Laund Road, Salendine Nook

Designers Response to Stage 1/2 Road Safety Audit

May 2018

Project 1387

DRAINAGE PLAN & DETAILS

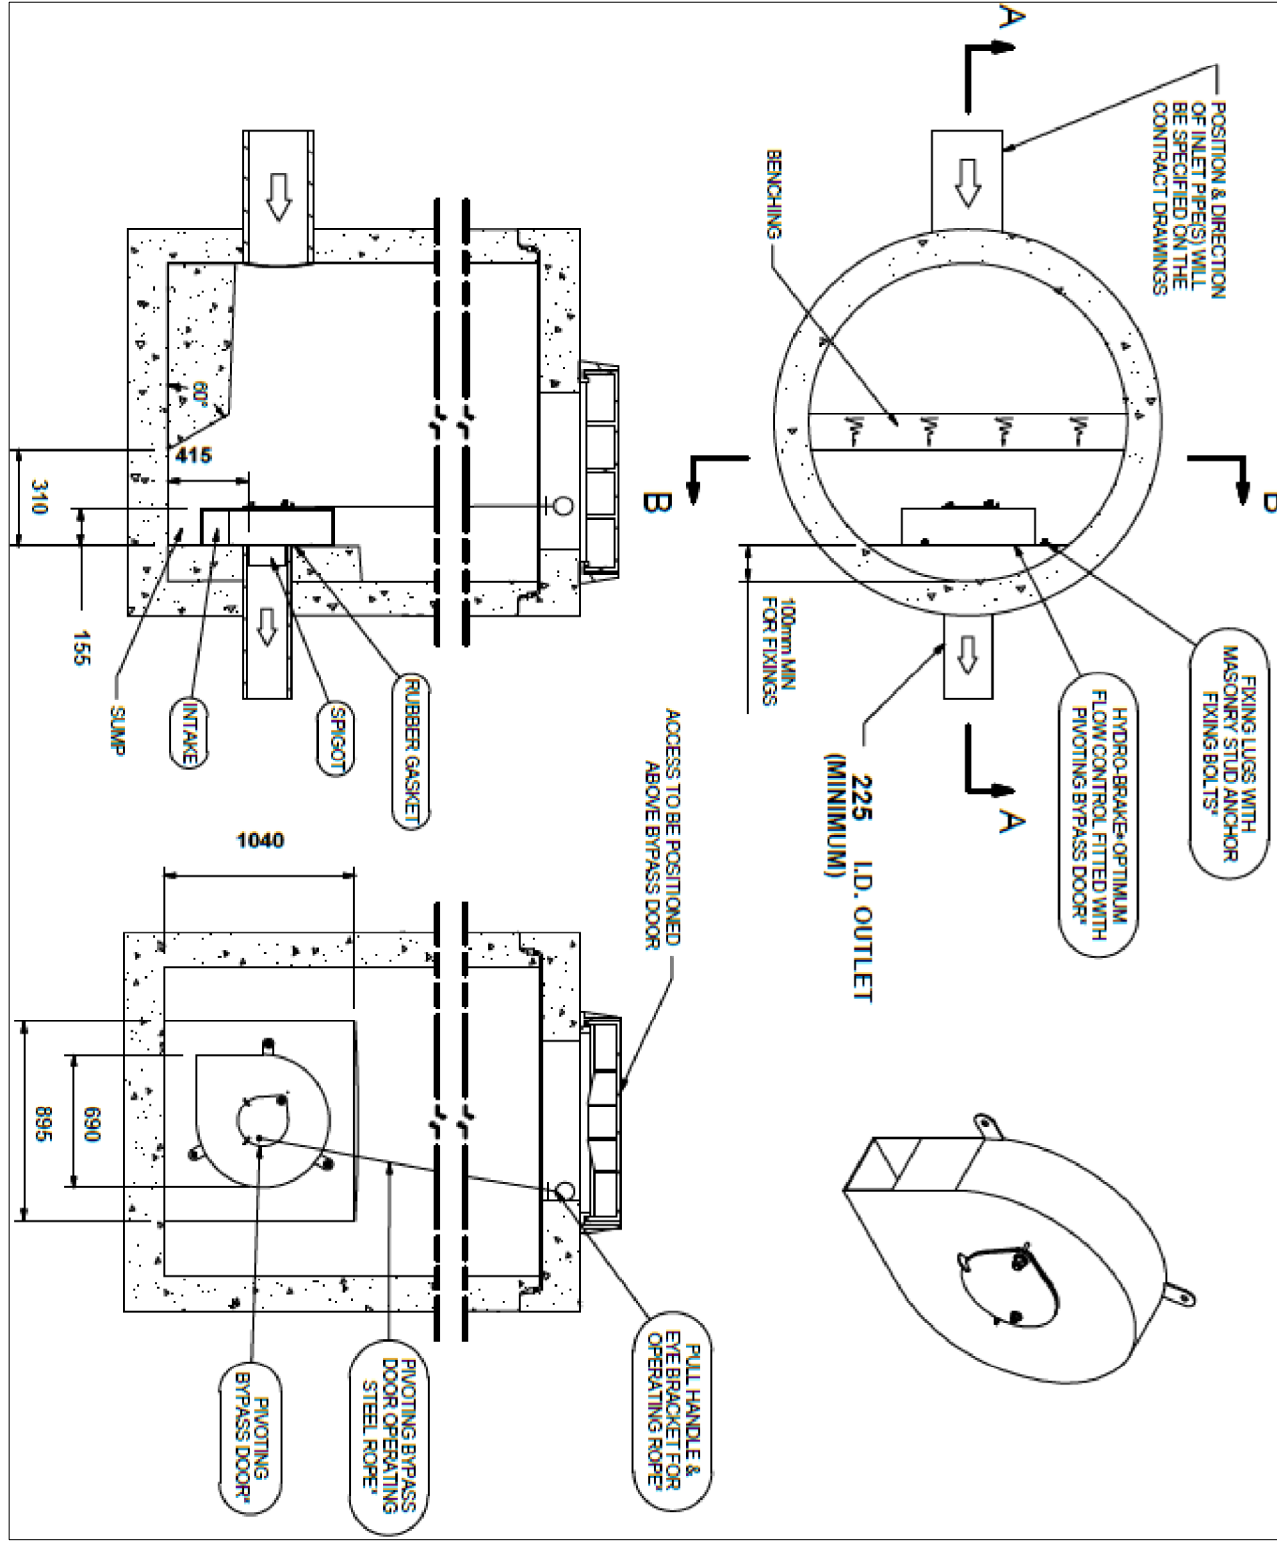
Location: New Access Road in front of existing row of cottages.

Summary: Risk of excessive water running into adjacent driveways to existing properties resulting in ice in freezing conditions.

Detail: The drawings show a narrow block paved margin with a vehicular dropped crossing and edging in front of the existing driveways that lead to the stone cottages. It appears that the road and surface water will fall in the direction of these properties. There is only one gully specified along this section and there is concern that during heavy rainfall this will not be adequate to catch all the surface water.

Ensure the drainage and gullies are adequate to catch the expected amount of surface water from the highway.

Gully provision is considered suitable to cater for the drained area of highway. Kerbs contain a 25mm upstand, and together with appropriate cross fall and end fall, surface water would be collected within the channel and drained within the gullies provided.

120 LAUND ROAD, SALENDINE NOOK		DRAWN BY MB
SECTION 38 DESIGN AND LONG SECTION		CHECKED BY AH

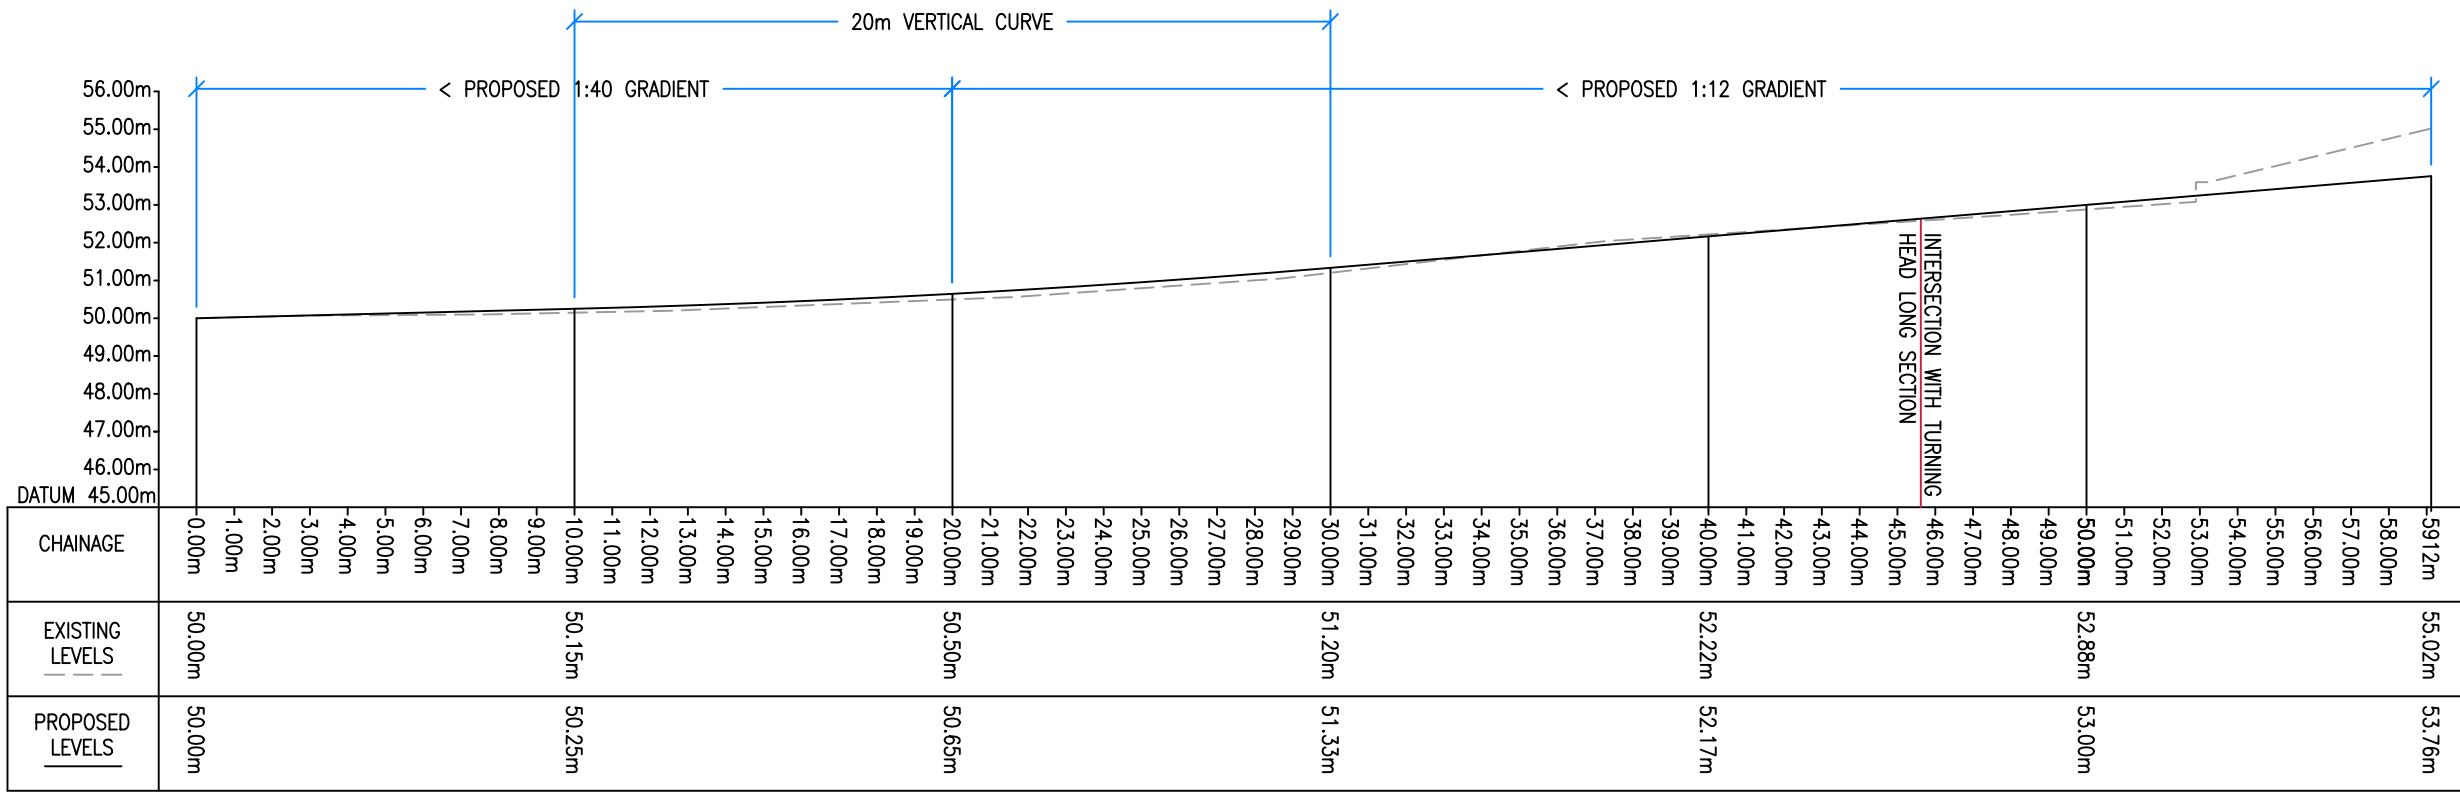
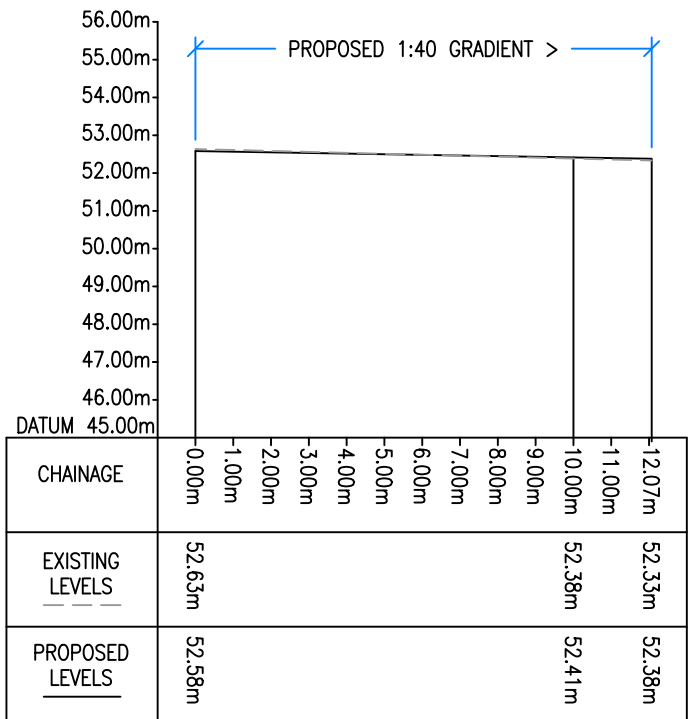
Location: New Access Road from Chainage 20 into turning area.

Summary: Steep gradient may cause pedestrian slips, trips and falls during inclement weather and / or collisions with vehicles.

Detail: The gradient is more than the maximum as recommended in the Standards and may cause safety issues particularly for pedestrians as there is no footway provided. During inclement weather if the road is icy and pedestrians are using the carriageway they may slip or conflict with vehicles also unable to drive safely on the incline.

Recommendation: Ensure the gradient of the road is acceptable for this type of development.

The layout of the road and vertical alignment has been agreed with KMC Highways Officers.
